From: Laura Gibbons
Sent: 29 May 2019 08:12
To: Stuart Corbey
Subject: RE: Worthing Road, Littlehampton - Planning application Ref: LU/59/19/PL

I have looked through the updated surface water drainage strategy and have the following comments:

## **Appendix E – Proposed Drainage Strategy**

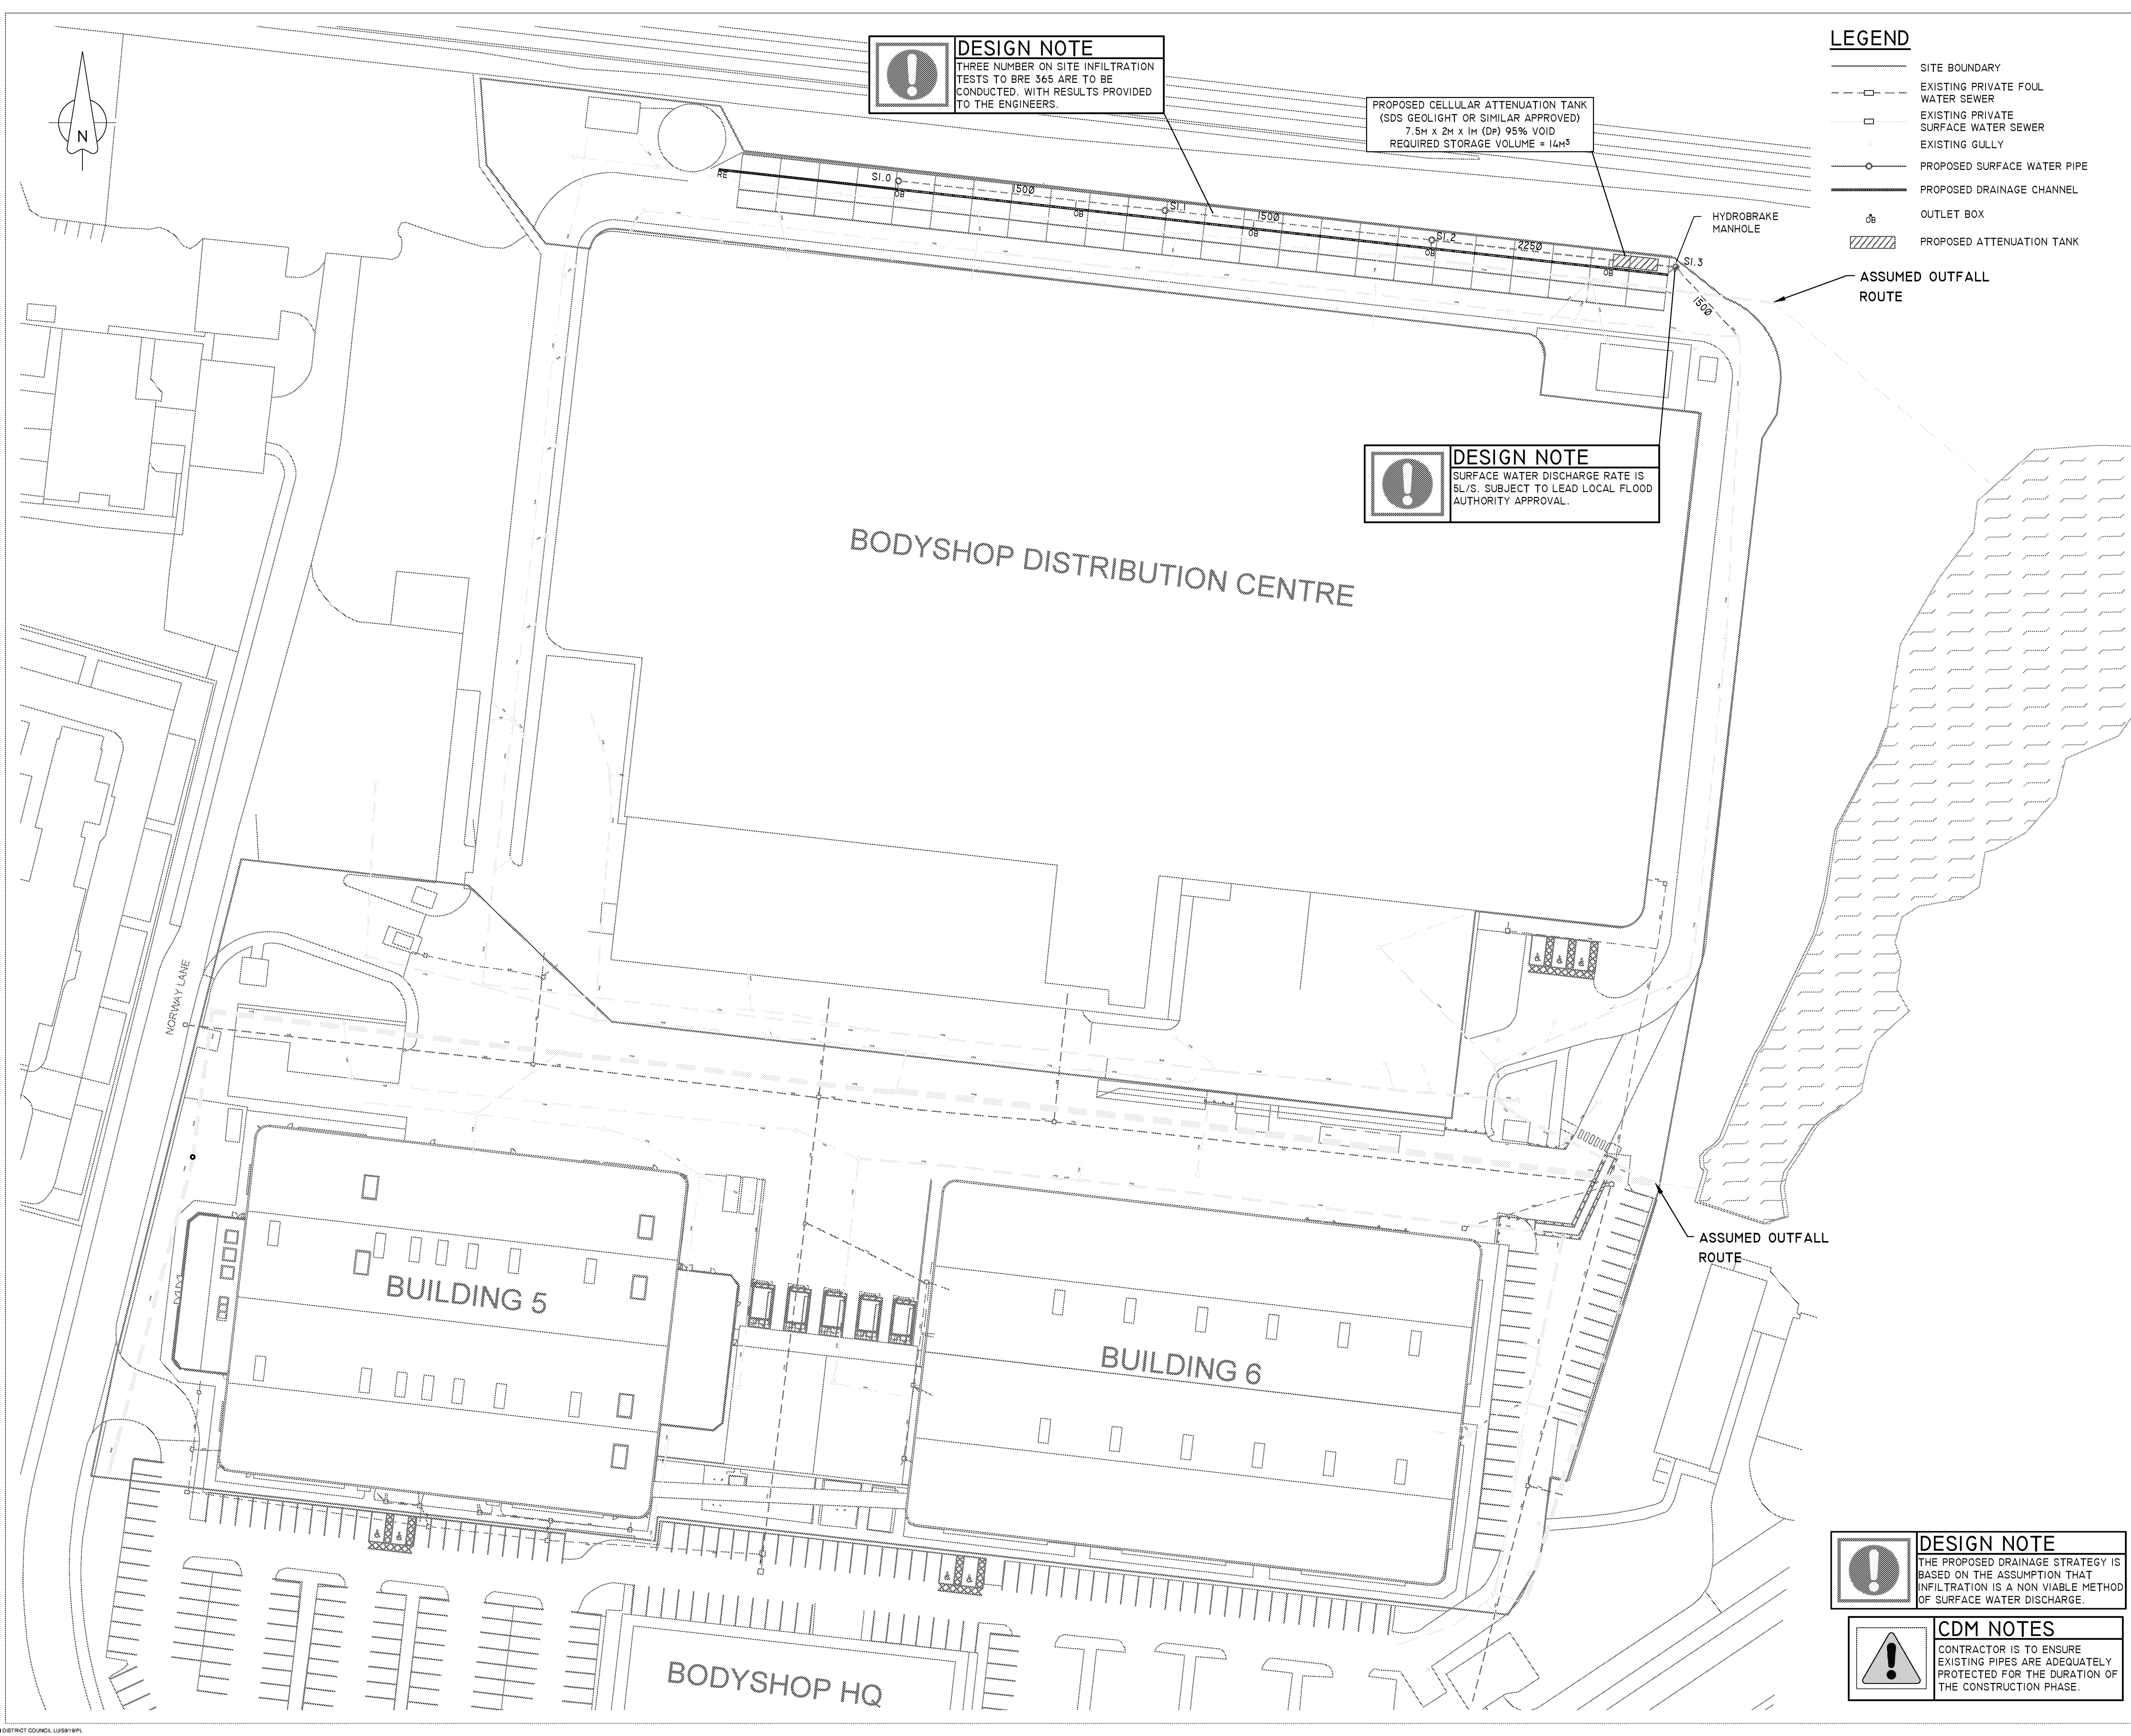
1. Worst case infiltration test results should be used in design, not an average.
2. What is the lifetime of the development, if it is over 40 years a 40% allowance for climate change should be utilised.
3. Safety factor of 4 is required, not 3.
4. Catchpits should be provided upstream of all connections to soakaways.
5. Please provide invert and cover levels on plan of inspection chambers/manholes.

Please find attached an updated Drainage Report that addresses the matters raised in your email of 20th May 2019.

1. Prior to the proposed surfacing works shown on plan reference DBN3-SMR-00-ZZ-DR-A-2009-S3-P1, winter groundwater monitoring to be undertaken to establish highest annual ground water levels and winter Percolation testing to BRE 364, or similar approved. The monitoring results and any necessary amendment to the proposed drainage strategy to be submitted to the local planning authority.
2. Until such time as the proposed surfacing works can commence pursuant to Condition 1, a temporary van staging area comprising temporary roadway aluminium mats to be utilised.
3. The approved drainage system to be installed in accordance with the details contained in the approved Drainage Strategy updated as necessary following winter ground water monitoring pursuant to Condition 1.
